Subject: Rezoning Petition Review

Date of Review: January 25, 2022 *(Revised March 29, 2022)*

Rezoning Petition #: 21-206

Location of Property: Approximately 4.20 acres located on the west side of N Tryon St, east of I-85 and south of W Mallard Creek Church Rd.

REZONING PETITION 2021-206  
RZ-2 : TECHNICAL DATA SHEET

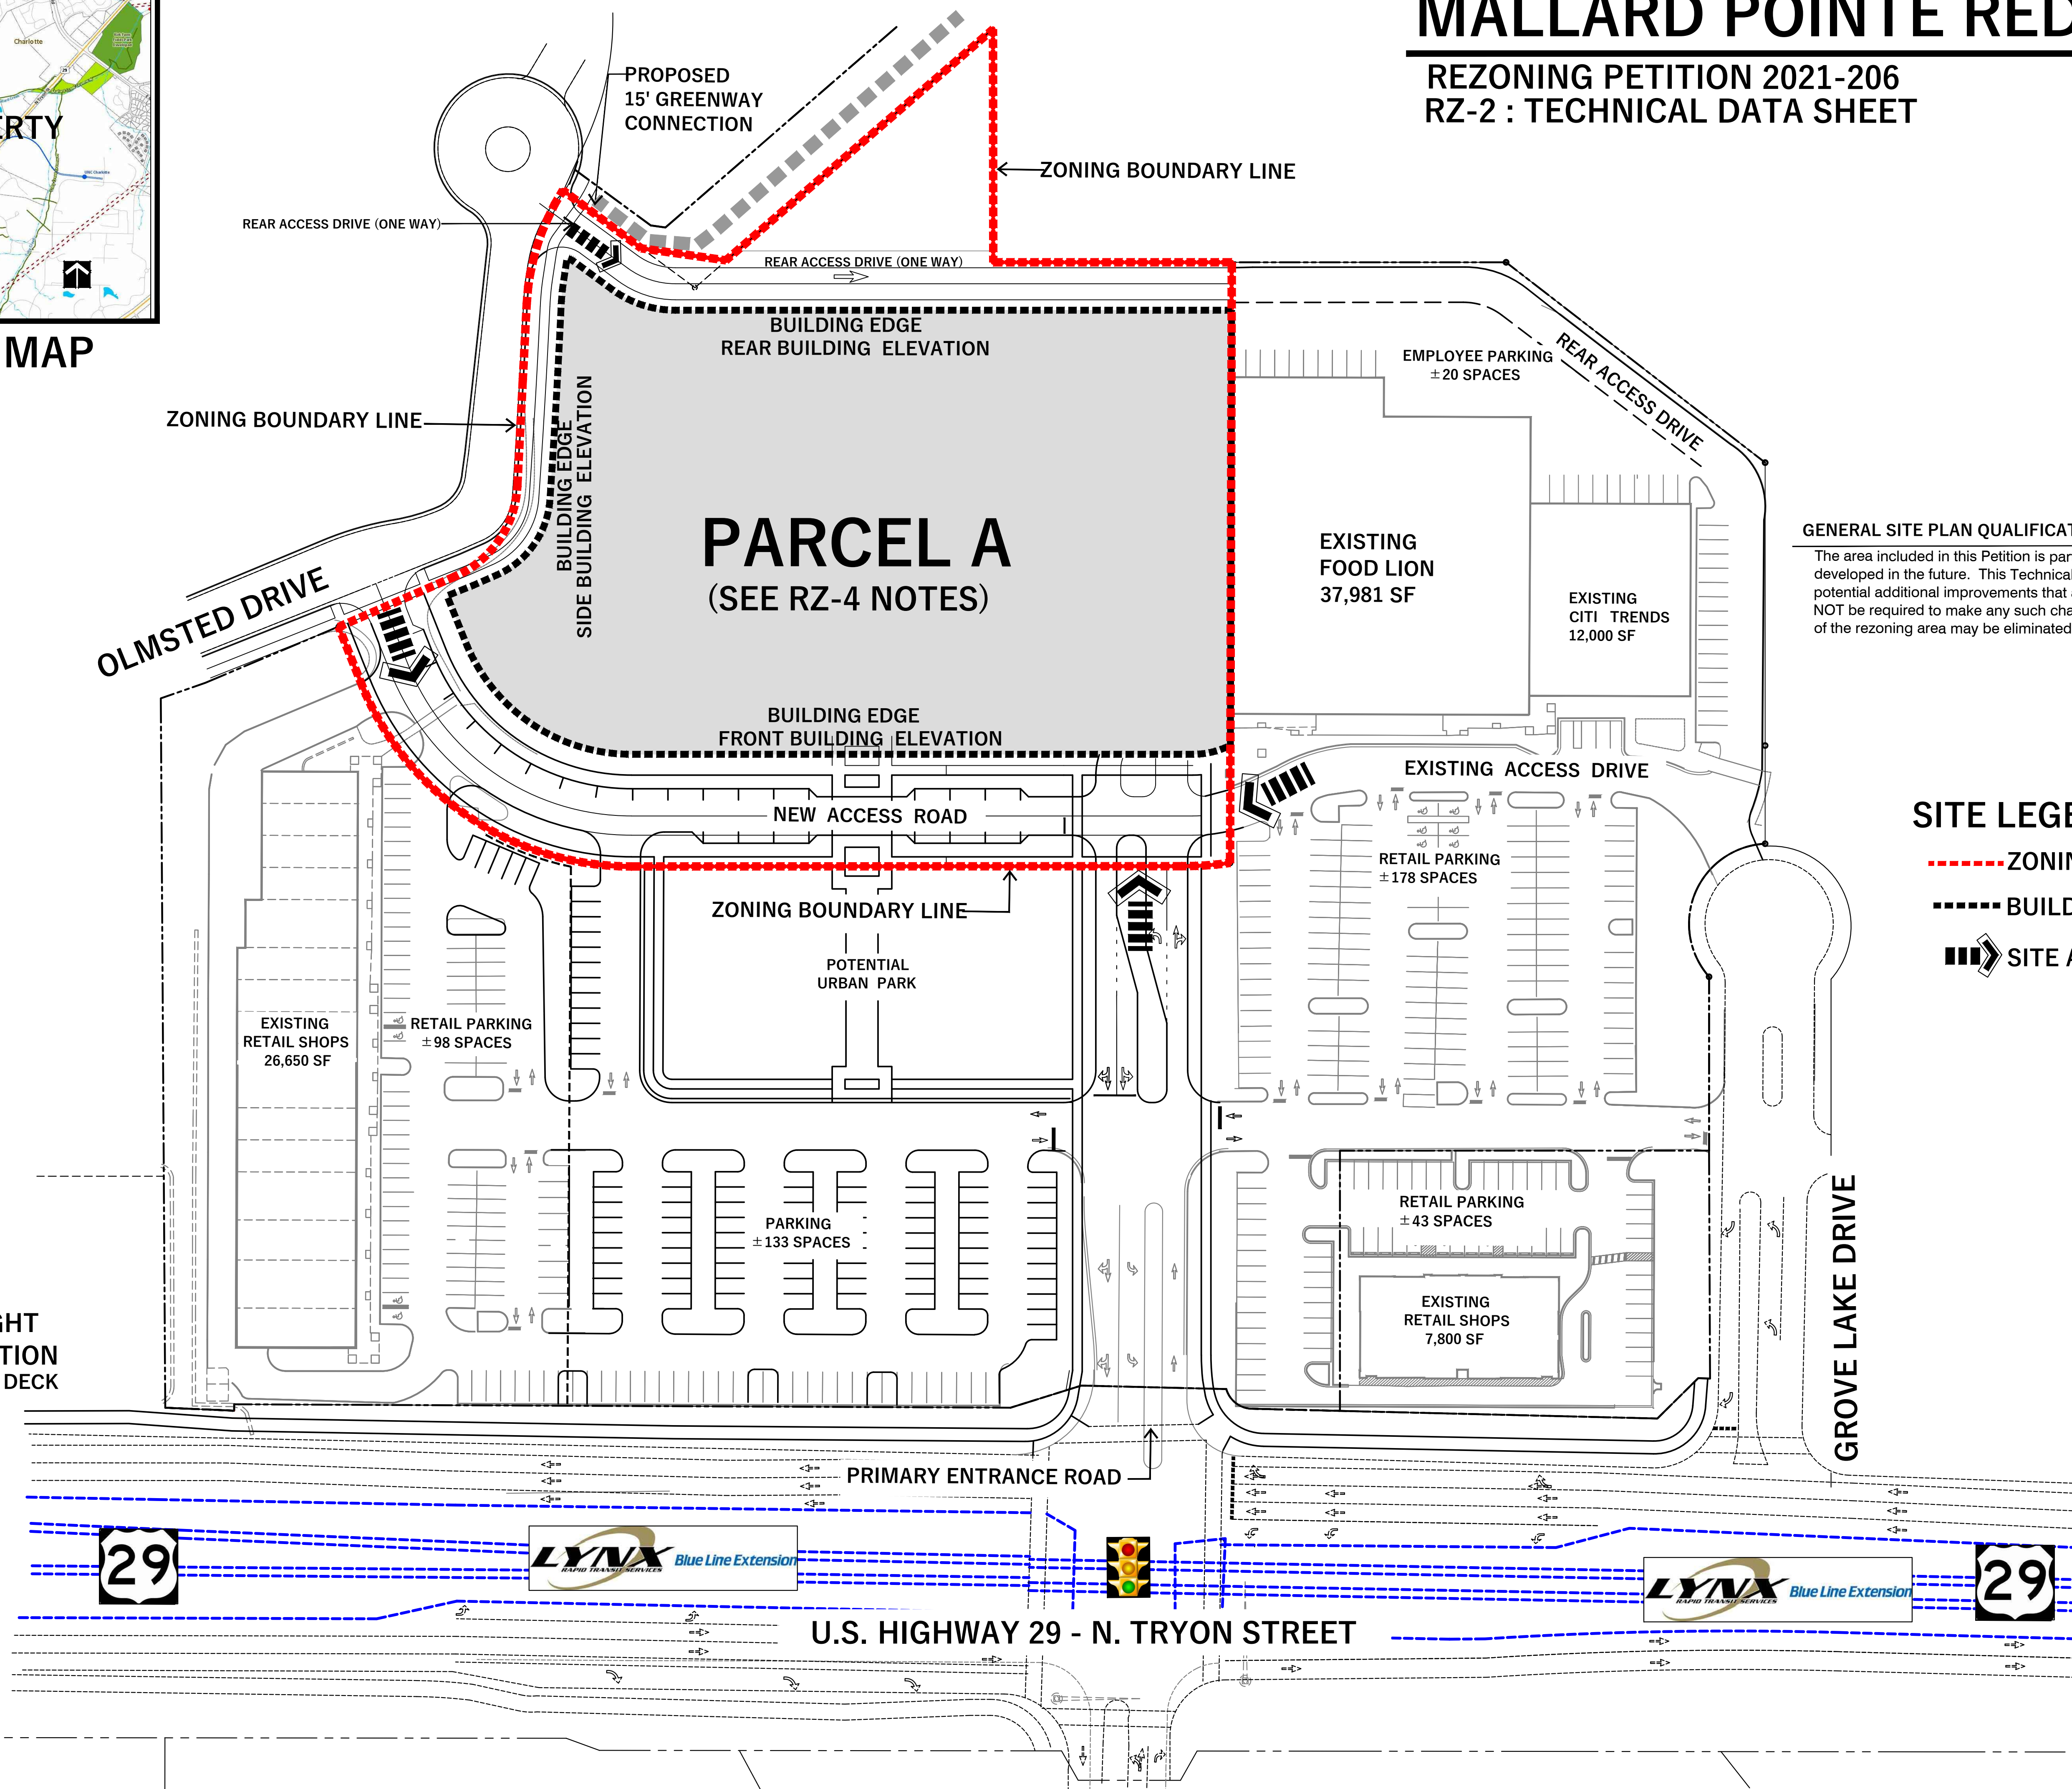
Please remove note 5a in its entirety as this is not determined or approved during the rezoning process.

This property drains to Mallard Creek, which is an impaired/degraded stream, and may contribute to downstream flooding. This project has the opportunity to mitigate future impacts to this stream, therefore, Storm Water recommends placing the following notes on the plan:

(I) Storm Water Quality Treatment

For defined watersheds greater than 10% built-upon area (BUA), construct water quality stormwater control measures (SCMs) designed for the runoff generated from the first 1-inch of rainfall for all new and redeveloped BUA associated with the project. SCMs must be designed and constructed in accordance with the Charlotte-Mecklenburg BMP Design Manual.

(II) Volume and Peak Control

For defined watersheds greater than 10% built-upon area, control the entire volume for the 1-year, 24-hour storm for all new and redeveloped BUA associated with the project. Runoff volume drawdown time shall be in accordance with the Charlotte-Mecklenburg BMP Design Manual.

For commercial projects with greater than 10% BUA, control the peak to not exceed the predevelopment runoff rates for the 10-yr, 6-hr storm and perform a downstream flood analysis to determine whether additional peak control is needed and if so, for what level of storm frequency, or if a downstream analysis is not performed, control the peak for the 10-yr and 25-yr, 6-hour storms.

For residential projects with greater than 10% BUA, control the peak to not exceed the predevelopment runoff rates for the 10-year and 25-year, 6-hour storms or perform a downstream analysis to determine whether peak control is needed, and if so, for what level of storm frequency.

Please remove note 5a in its entirety and replace with the following;

This property drains to Mallard Creek, which is an impaired/degraded stream, and may contribute to downstream flooding. This project has the opportunity to mitigate future impacts to this stream, therefore, Storm Water recommends placing the following notes on the plan:

(I) Storm Water Quality Treatment

For defined watersheds greater than 10% built-upon area (BUA), construct water quality stormwater control measures (SCMs) designed for the runoff generated from the first 1-inch of rainfall for all new and redeveloped BUA associated with the project. SCMs must be designed and constructed in accordance with the Charlotte-Mecklenburg BMP Design Manual.

(II) Volume and Peak Control

For defined watersheds greater than 10% built-upon area, control the entire volume for the 1-year, 24-hour storm for all new and redeveloped BUA associated with the project. Runoff volume drawdown time shall be in accordance with the Charlotte-Mecklenburg BMP Design Manual.

For commercial projects with greater than 10% BUA, control the peak to not exceed the predevelopment runoff rates for the 10-yr, 6-hr storm and perform a downstream flood analysis to determine whether additional peak control is needed and if so, for what level of storm frequency, or if a downstream analysis is not performed, control the peak for the 10-yr and 25-yr, 6-hour storms.

For residential projects with greater than 10% BUA, control the peak to not exceed the predevelopment runoff rates for the 10-year and 25-year, 6-hour storms or perform a downstream analysis to determine whether peak control is needed, and if so, for what level of storm frequency.
